DECISION DELEGATED TO DEVELOPMENT MANAGER

Application No: H16-0040-21 **Applicant:** Mr T Burrows
Proposal: Change of use from barn to residential dwelling
Location: South Drove North Spalding
Terminal Date: 30th March 2021

SITE PLAN & PROPOSED SITE LEVELS
1:500

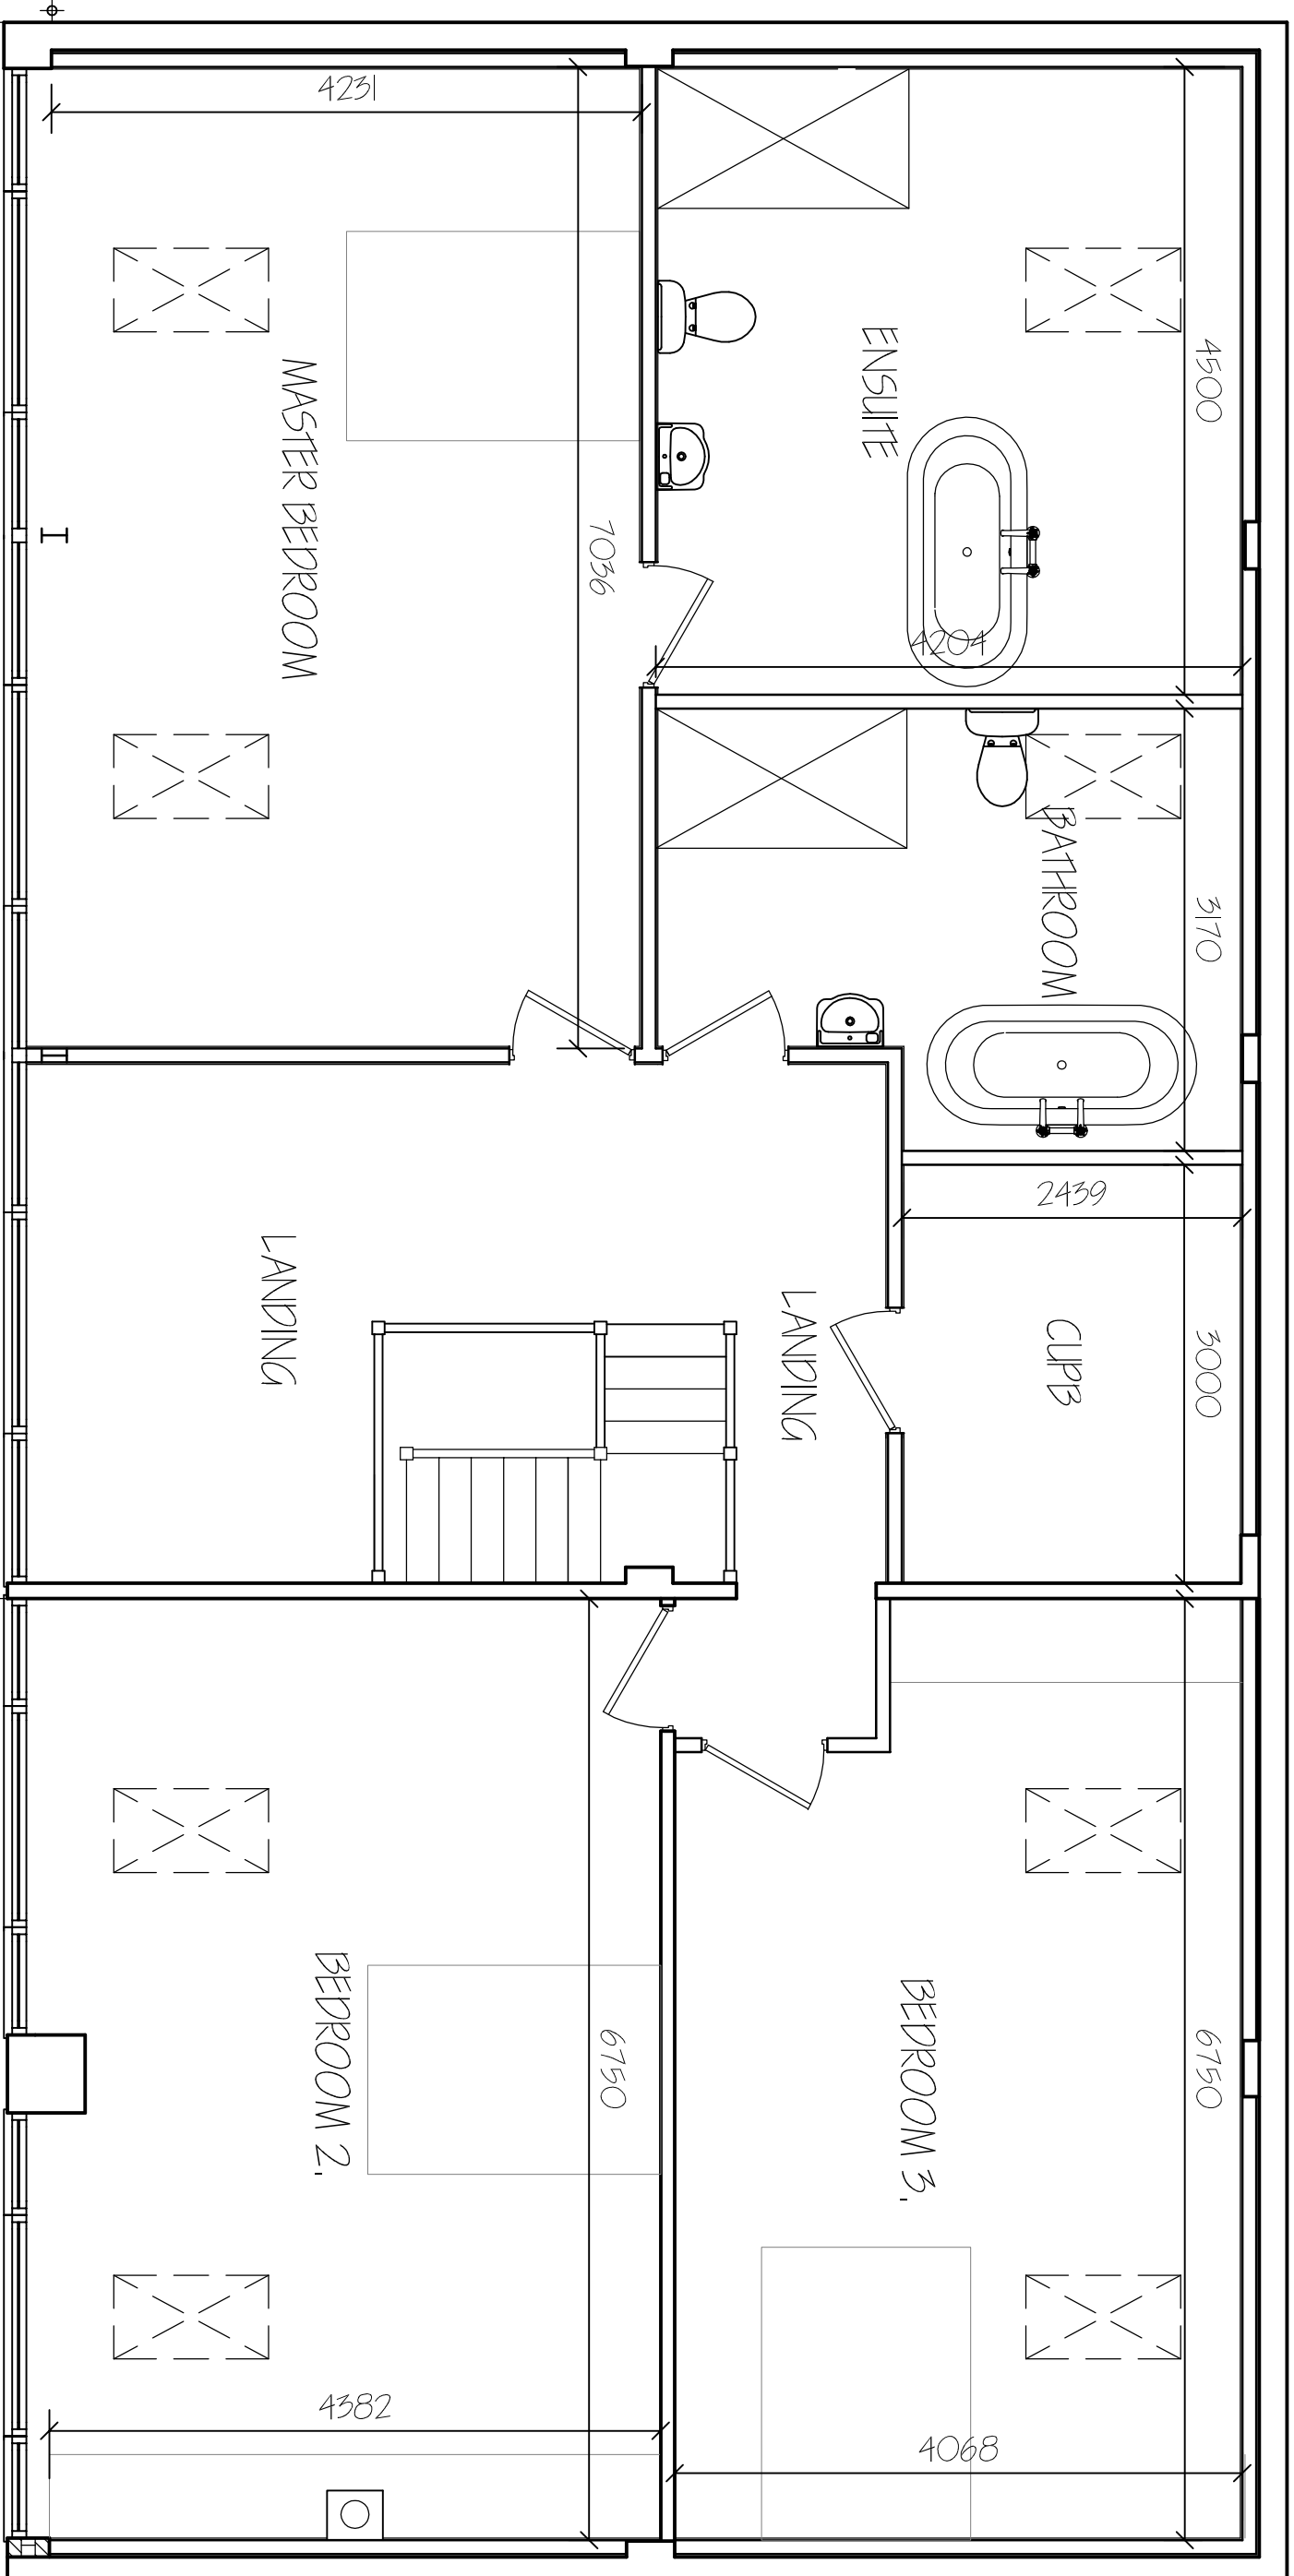
The application sets out a curtilage area that shows the extent of garden curtilage land being greater than the interpretation of curtilage for the purposes of Part Q of the GDPO, which is set out above.

The application sets out a curtilage area that shows the extent of garden curtilage land being greater than the interpretation of curtilage for the purposes of Part Q of the GDPO, which is set out above. For this reason the development cannot be considered as permitted development under Part Q.
